September 20, 2016

Re: REVISED HYDRAULIC ANALYSIS ADDENDUM TO THE AMENDMENT TO THE DMP TRAILS UNITS 1, 2, AND 3 DRAINAGE REPORT, ENGINEER'S STAMP DATED 9-14-2016 (FILE: C09D001)

Attached is the revised Hydraulic Analysis Addendum to the Amendment to the DMP Trails Units 1, 2, and 3. This addendum reflects the changes made to address your comments in a letter dated January 2, 2015. The following is a list of your comments with our responses in bold font.

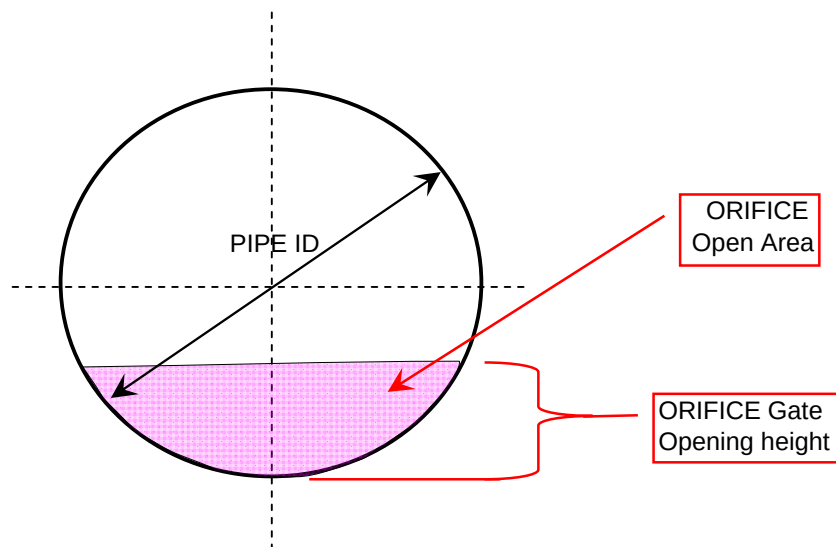
- Orifice Plate in Pond H is to be 1.83 sq. ft.
See updated orifice plate and resulting flow rates in the PCSWMM model.
 - BHI states that their field survey indicated that the pipe out of Pond H is 36" dia, rather than 30" as indicated on the As-builts. (Links L-H and L104)
Actual pipe diameter is 36" and is modeled as such. Pipe diameter also verified in the field.

City Project No. 730084 Zone Map No. C-9-Z Sheet 19 of 51

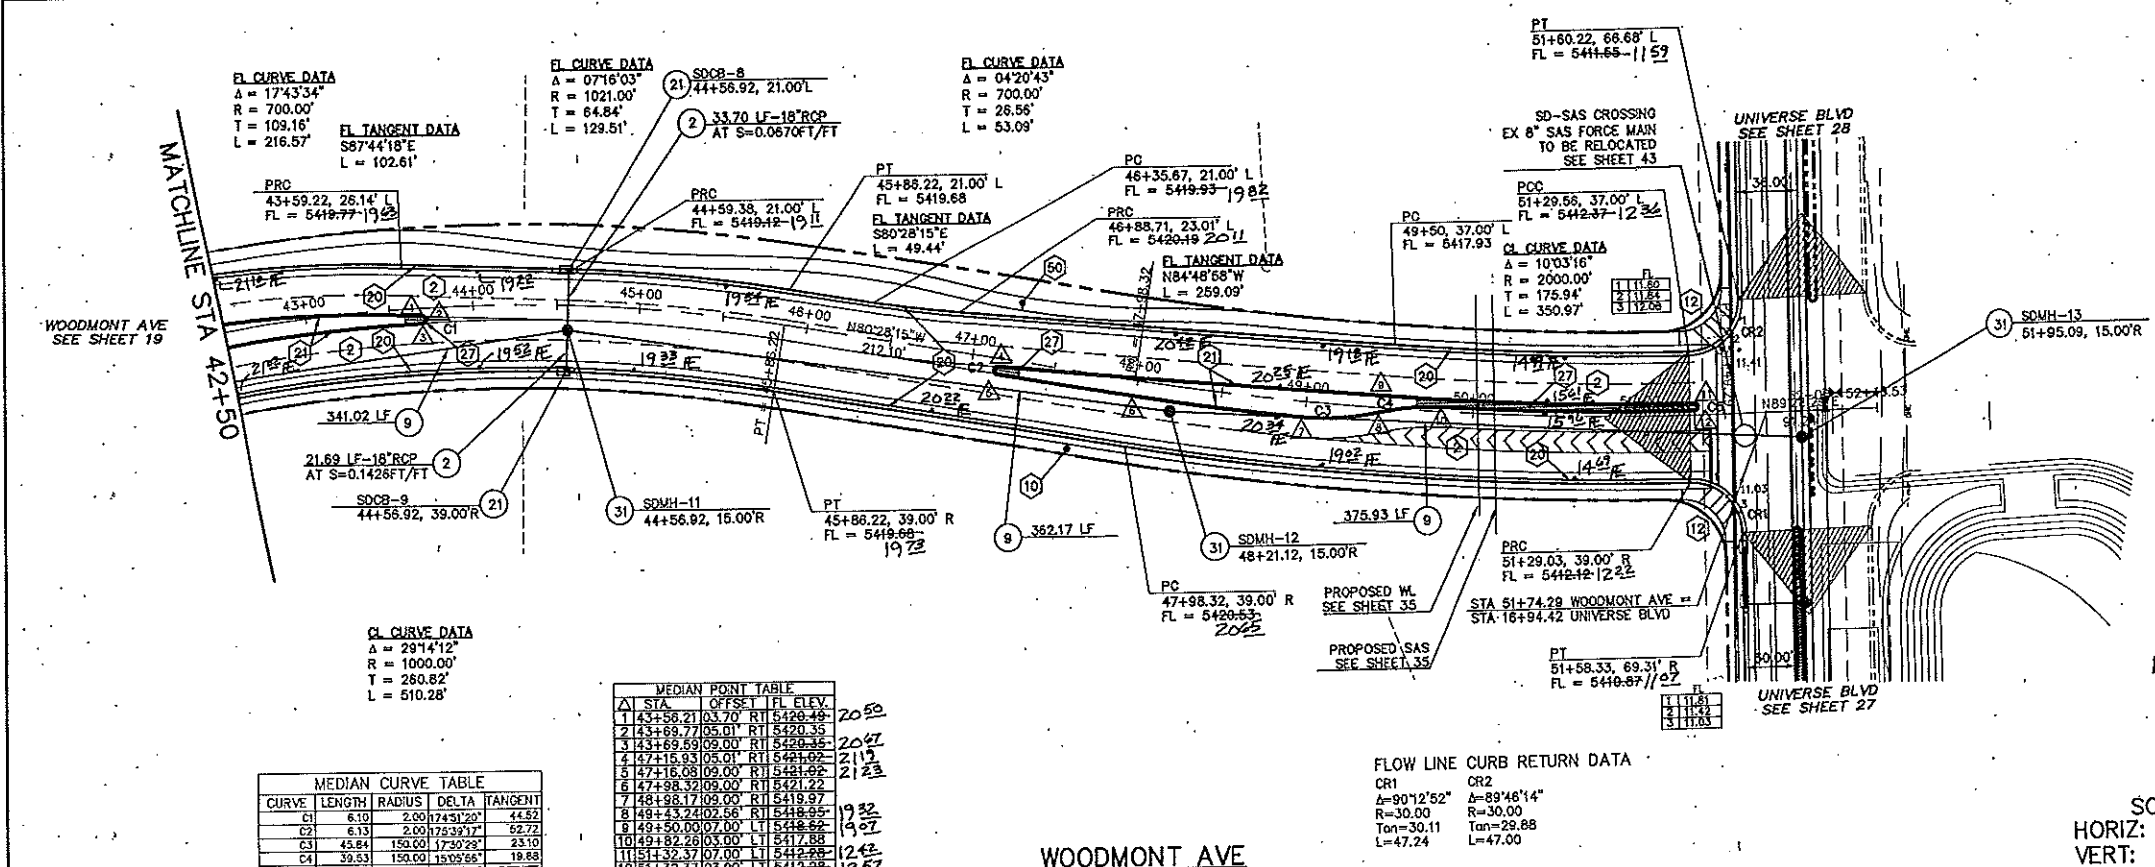
- Link L-13: D/S Invert is 5403.05 (the design value) but the As-built value is 5402.03 per CPN 730084 Sheet 20/51 for a difference of 1'. The HGL is 5410.98 and adding 1' makes it 5412. The Rim is 5411.23, so the HGL is above the Rim.

Updated PCSWMM model reflects as-built invert value.
